Whalley Parish Council

PLANNING APPLICATIONS

3/2012/1079

Location: Green Solicitors 79 King Street Whalley BB7 9SW

DRAWING TITLE
EXISTING ELEVATIONS & FLOOR PLANS

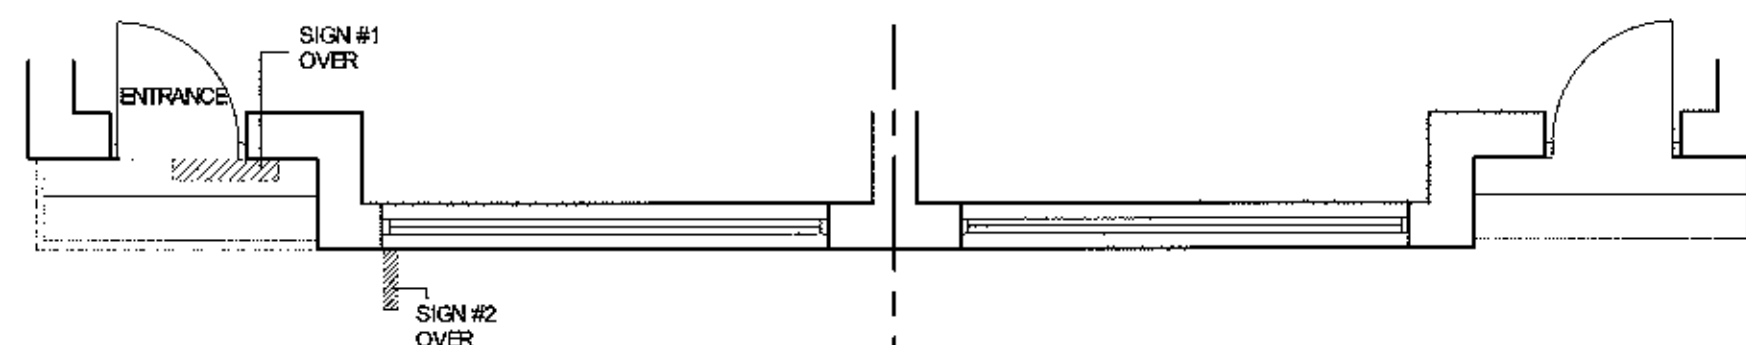
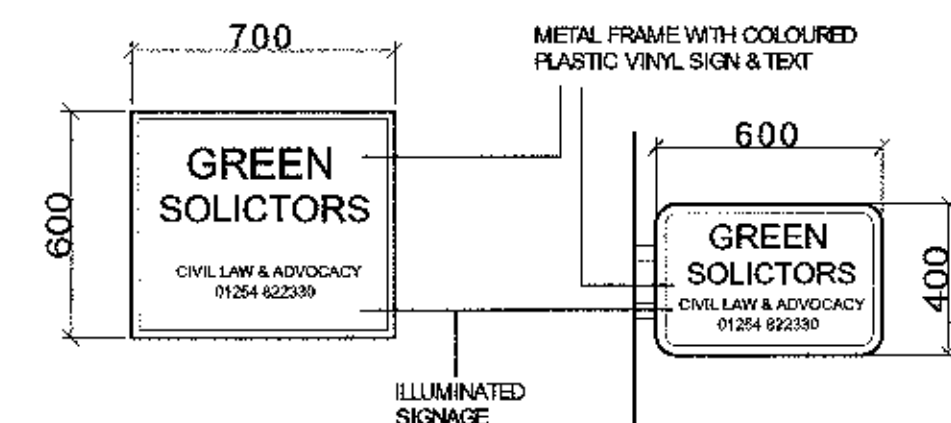
The parish council regrets that the signs have been erected without planning permission.

It is considered that the existing sign will not make a positive contribution to the significance of the historic environment and does not reflect the character and appearance of the Conservation Area, contrary to Policy ENV16. The method of illumination is not considered to be appropriate, nor sympathetic to this traditional shop front and thus appears obtrusive in the street scene. The visual green prominence of the signs (especially at night) has a significant visual impact upon the appearance of the premises and the Conservation Area.

Policy S14 with respect to Conservation Areas states (i) "council will seek a high standard of design which should conserve or enhance features or architectural or historic interest"; (ii) "Traditional fascia design with indirect lighting will be considered appropriate". The application does not meet either of these criteria.
